Application Ref:	3/2021/0544	 <div>Ribble Valley Borough Council</div> <div>www.ribblevalley.gov.uk</div>	
Date Inspected:	N/A		
Officer:	BT		
DELEGATED ITEM FILE REPORT:		Decision	Approval

Development Description:	Proposed erection of a single storey side extension and a single storey rear extension.
Site Address/Location:	7 Milbeck Close, Longridge. PR3 3LQ

PROPOSED REAR ELEVATION

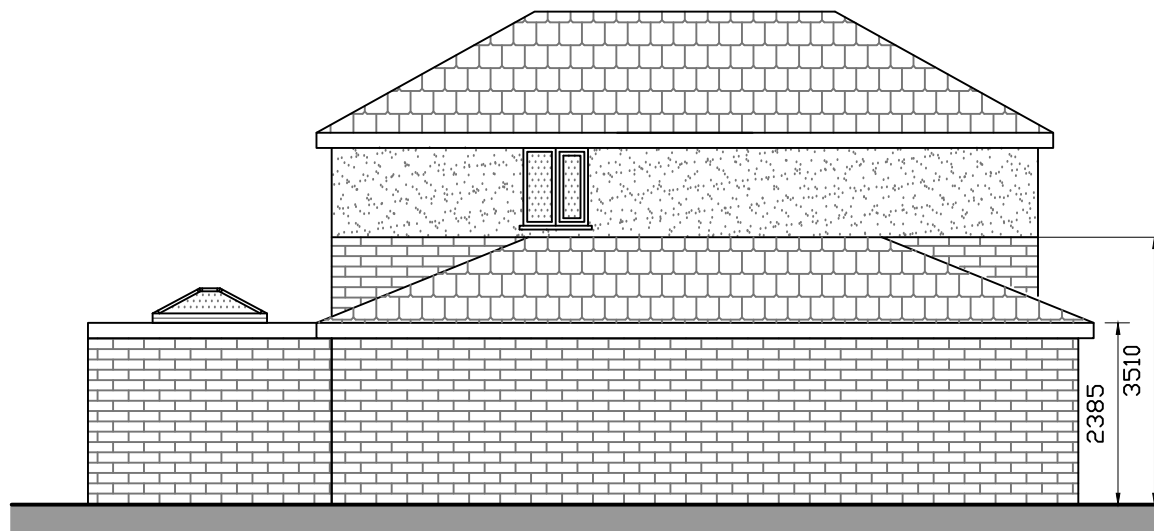
The proposed single storey rear extension would extend beyond the rear wall of the original dwellinghouse by 3.2 metres and measure 2.8 metres in height.

PROPOSED SIDE ELEVATION

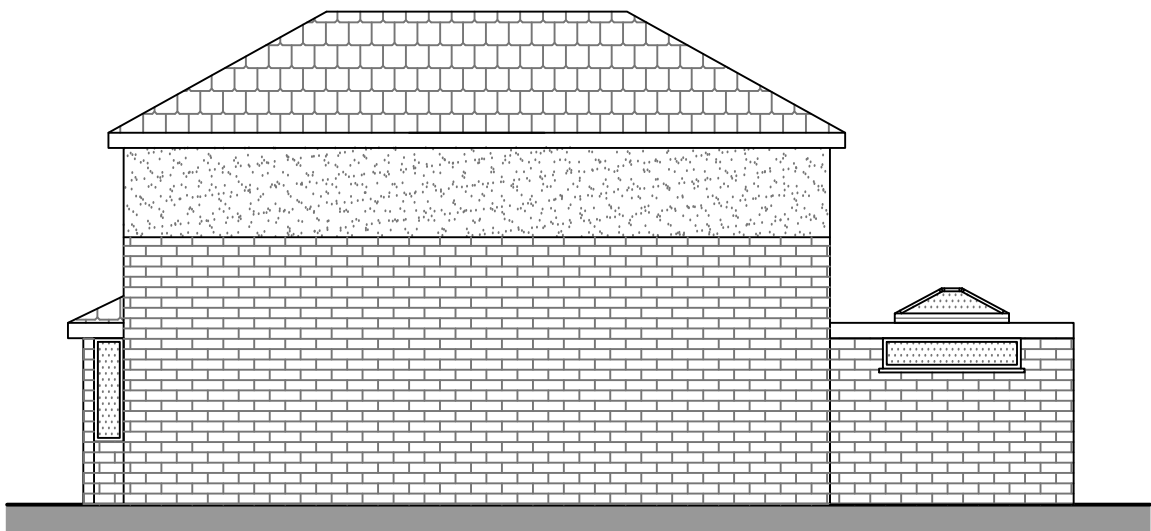
The proposed single storey side extension would be within 2 metres of the boundary of the curtilage of the dwellinghouse and would be 2.3 metres in height to the eaves measured from the highest part of the surface of the ground adjacent to it.
